Submission 3rd Track Epping - Thornleigh

Bottleneck Epping station: 4 tracks narrowing down to 3 tracks.
The whole Northern line needs to be quadruplicated and very soon

3rd track design to be compatible with quadruplication

Figure 5.4 Cross-section and elevation – New Cheltenham Station concourse building

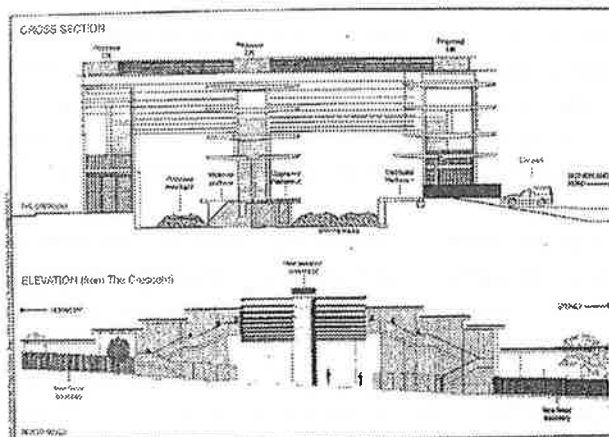
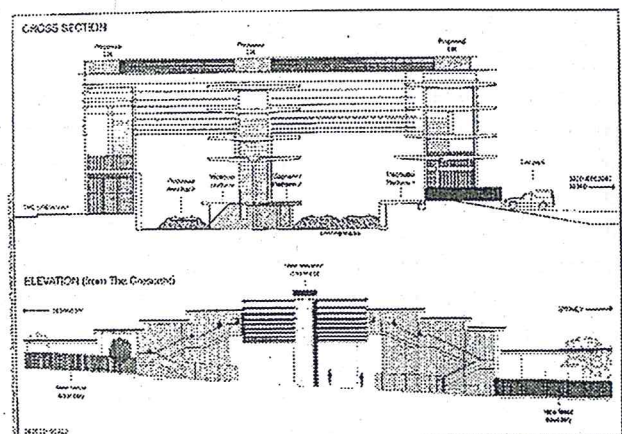
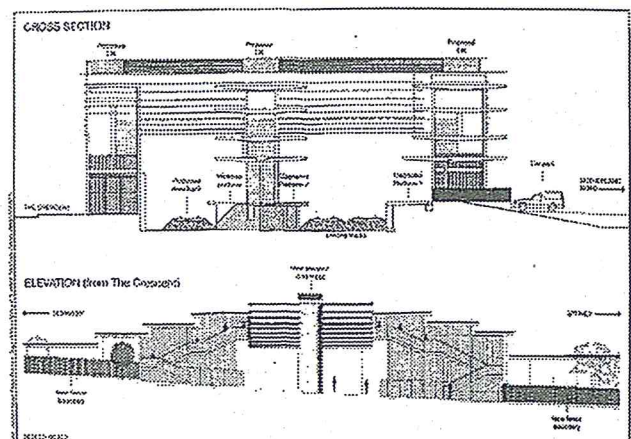
Looking North. Shortsighted designs for 3 tracks only. Location of lift and concourse must accommodate 4th track. The cross section below shows a museum type diesel loco (and in the wrong direction). This reveals the mindset of planners. Although the documentations says the 3rd track will be electrified (so it can be used by the Newcastle express) they do not intend to electrify the whole rail system (at this stage, anyway!)
